Ramsgreave Parish Council – Formal Objection to Planning Application by Persimmon Homes (Land at Salesbury View, Wilpshire)

Application 3/2025/0801

Figure 4: Landscape Masterplan

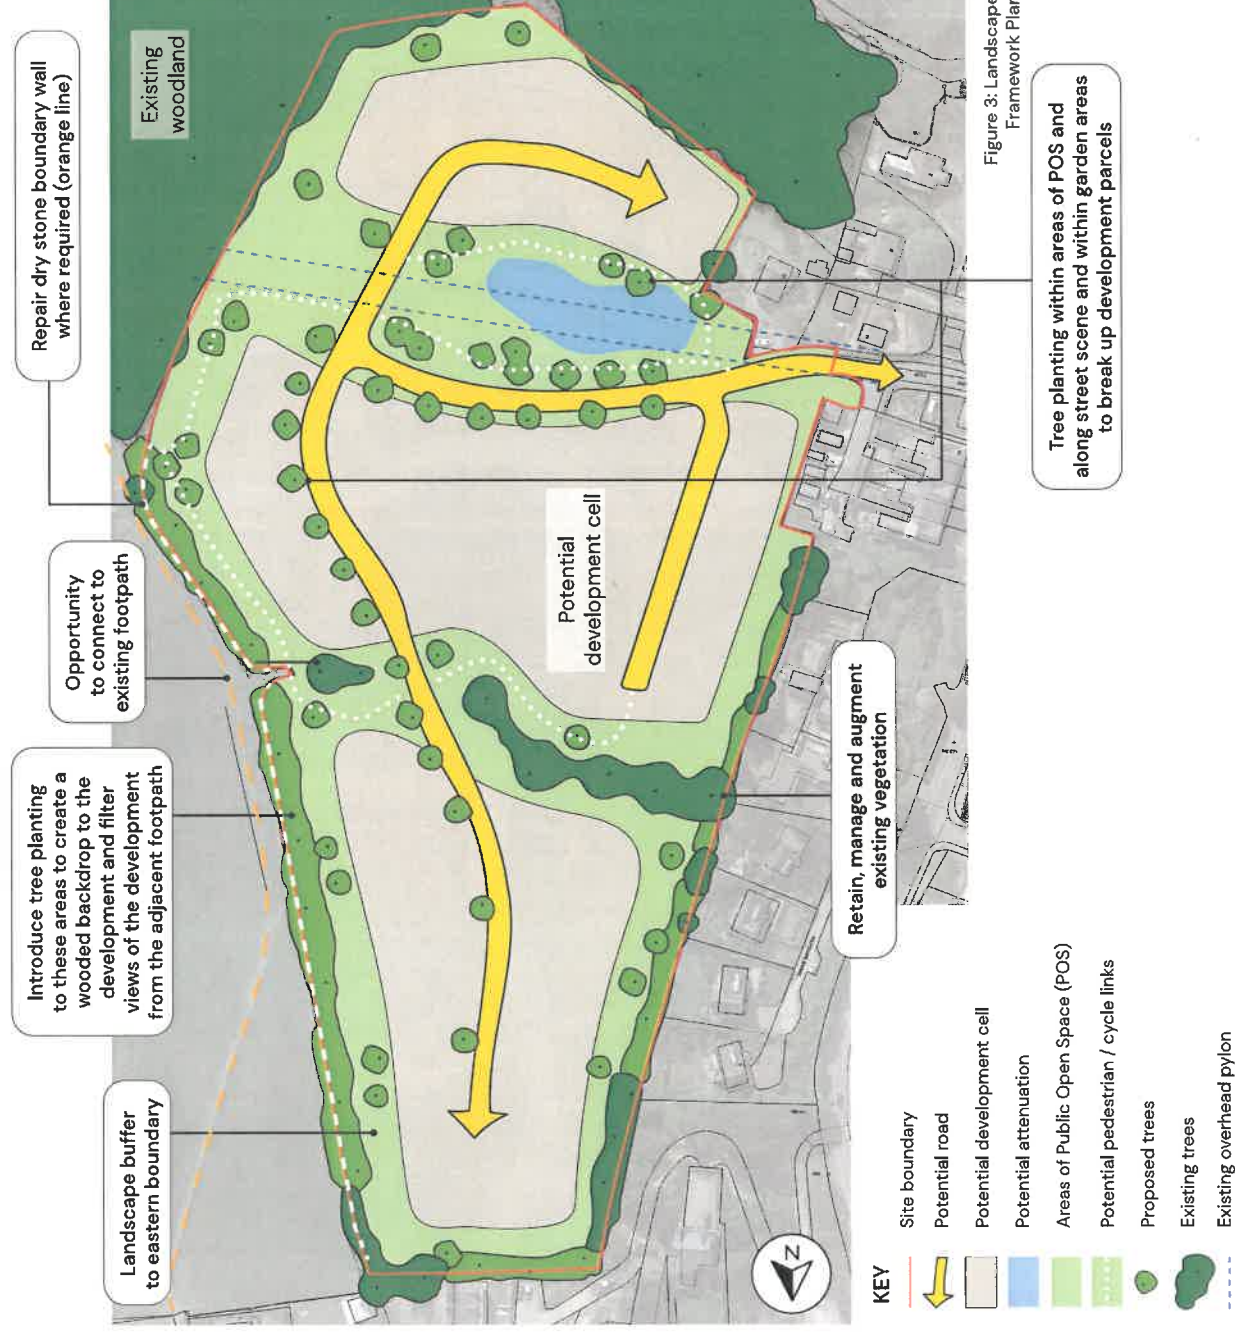
The revised landscape buffers do not mitigate the harm and cannot disguise a suburban estate on a steep open hillside. The Inspector previously concluded such buffers would be ineffective, and nothing in the current proposal contradicts this conclusion.

Figure 8: Screened ZTV with Viewpoints

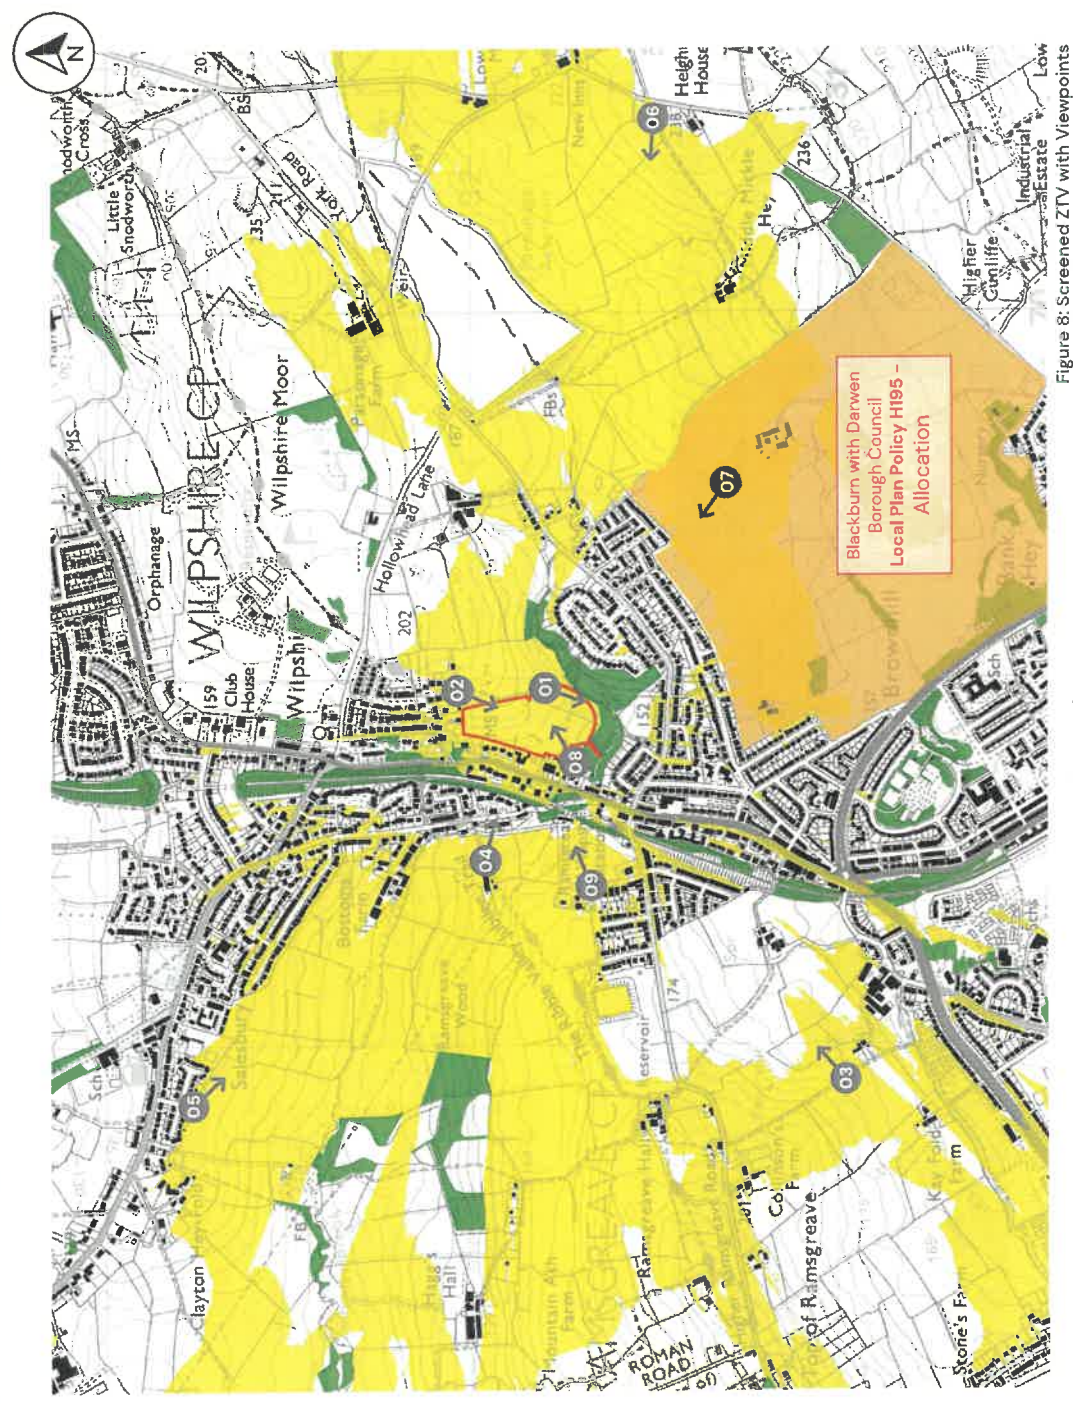
The developer's Landscape and Visual Impact Assessment is selective in its viewpoints and does not present an accurate picture of the visibility of the scheme from surrounding areas, including Ramsgreave - see Figure 1.
